**KIRKLEES METROPOLITAN COUNCIL
INVESTMENT & REGENERATION SERVICE**

Reference No: 2020/62/90133/E

Site Address: 1, Chapel Royd, Emley, Huddersfield, HD8 9GN

Description: Erection of extension to garage and front and rear dormer windows

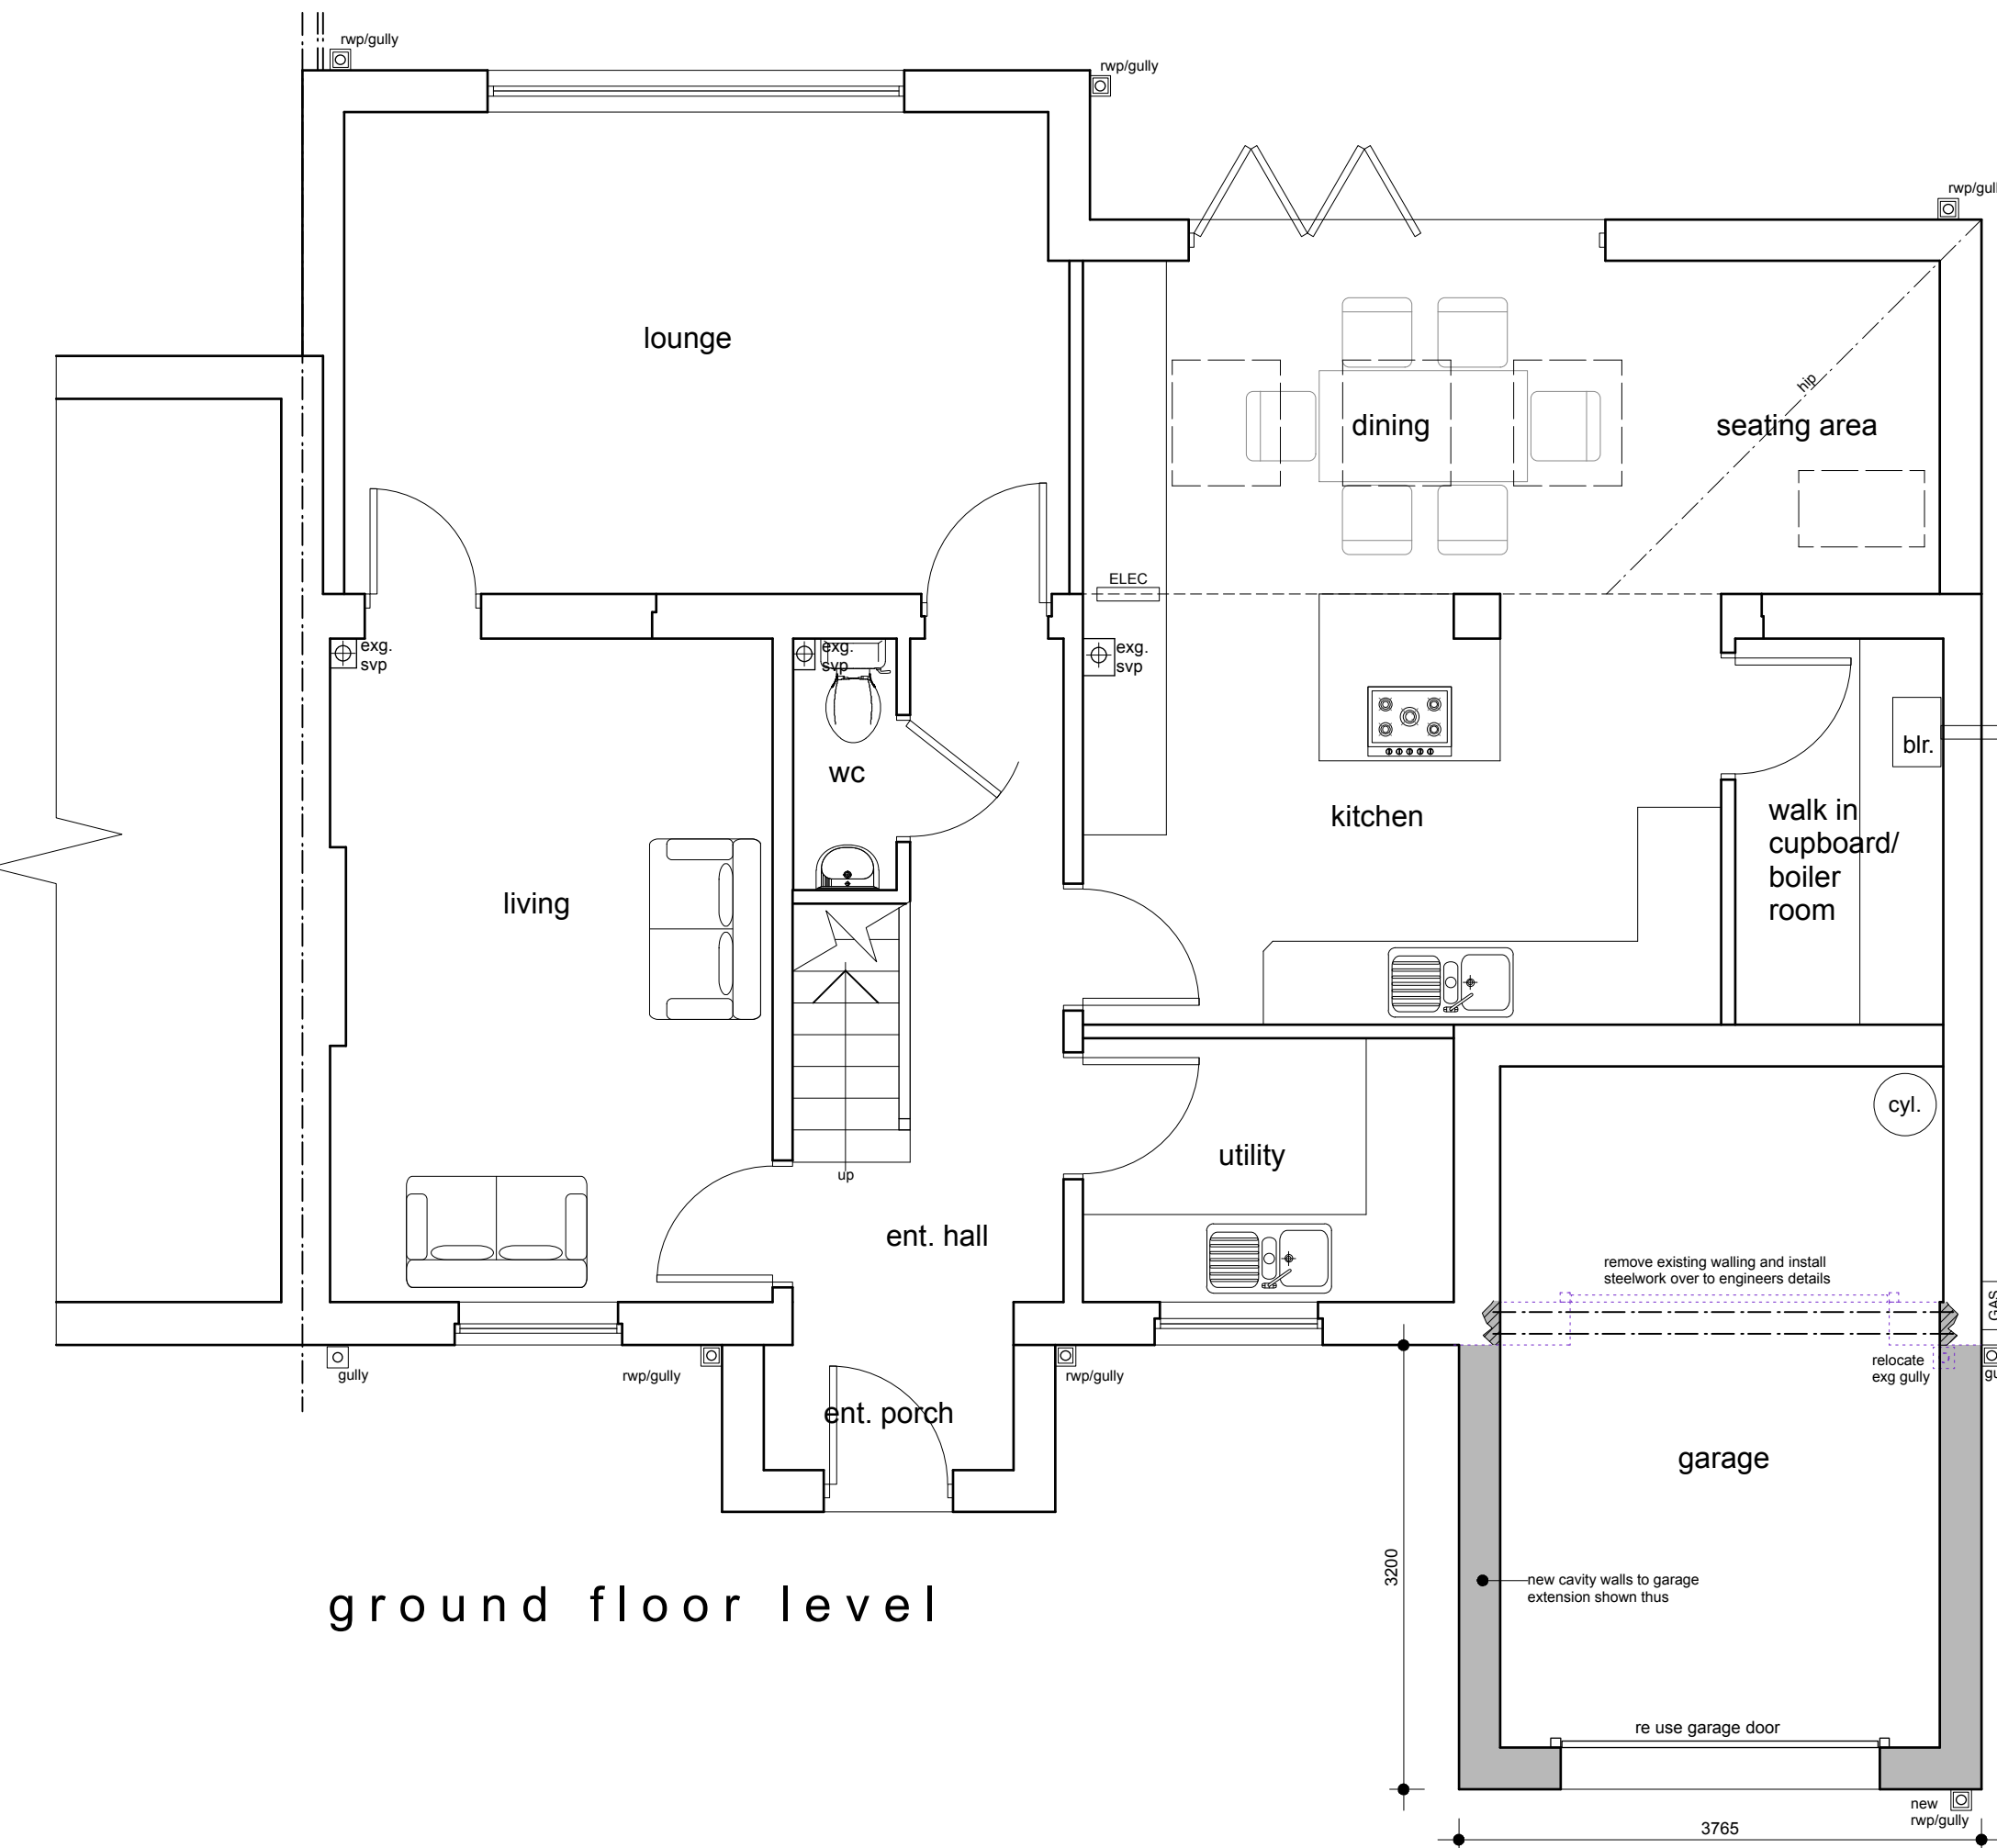
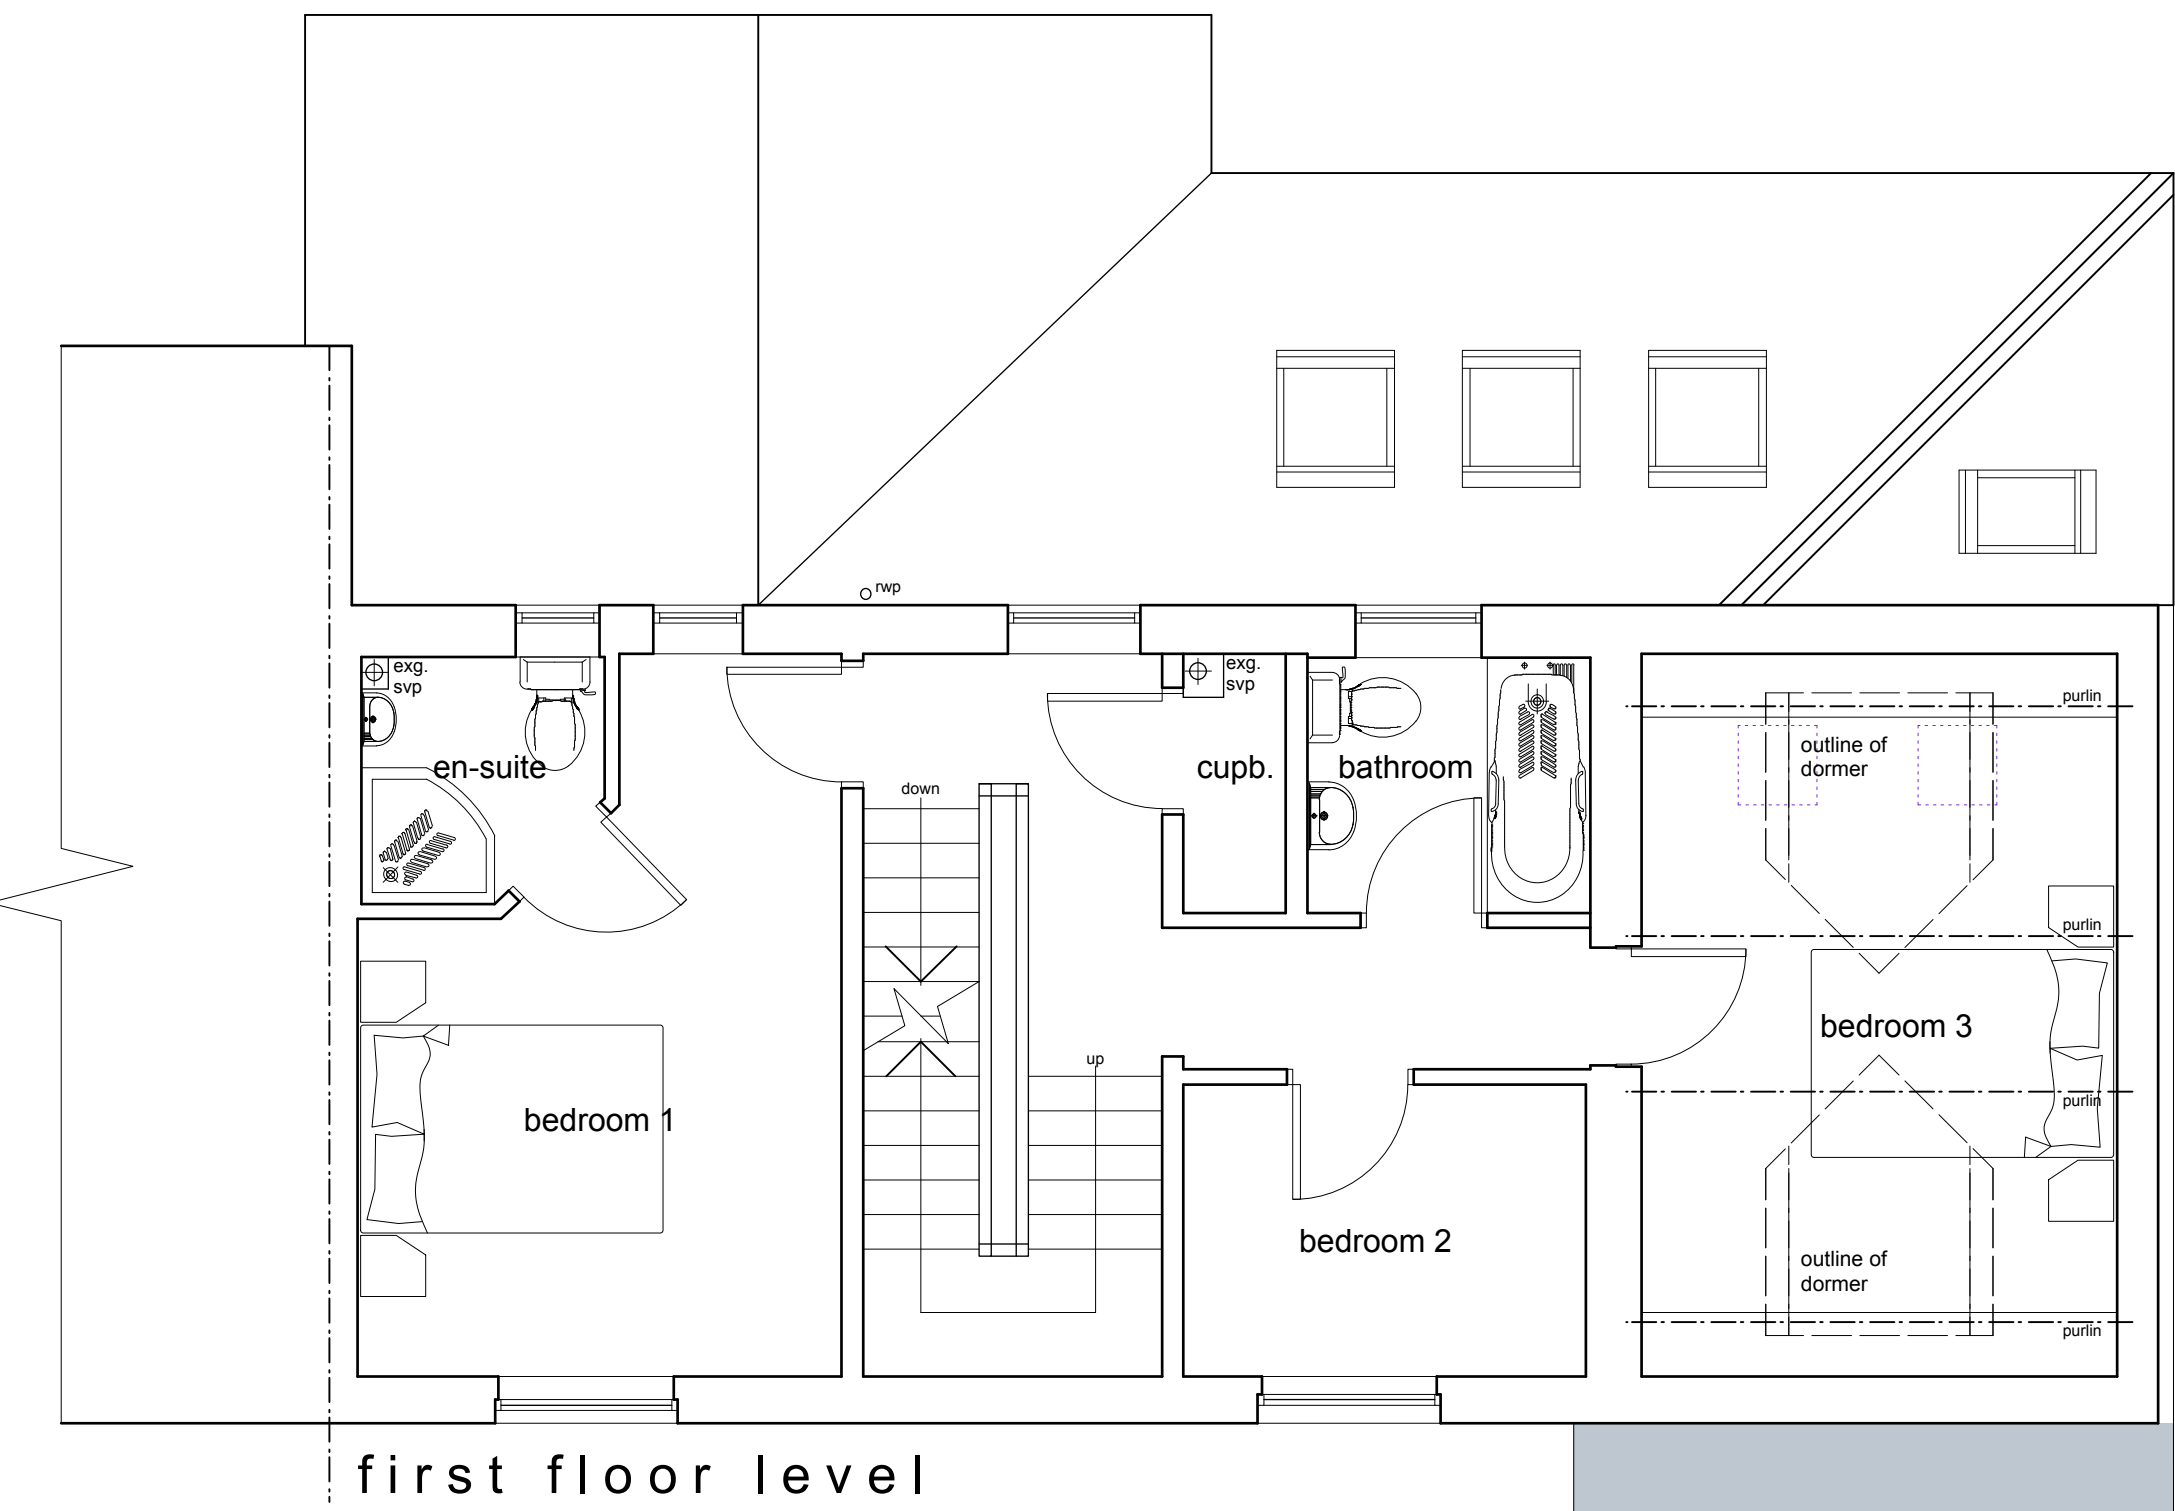
Officers raised concern with the agent regarding the relationship between the garage extension and the host property and suggested that this element be removed from the proposal. The agent submitted amended plans replacing the original gable roof form with a catslide roof form. The amended plans are considered to, on balance, address officers concerns.

Whilst the amended plans would result in a small increase in the maximum height of the garage extension, as a result of the introduction of a catslide roof form, it is considered that the overall impact on the adjacent properties would be reduced. As a result, and due to the nature of the amendments which replace the proposed roof form of the garage extension, it was not considered necessary to advertise the amended plans in this instance.
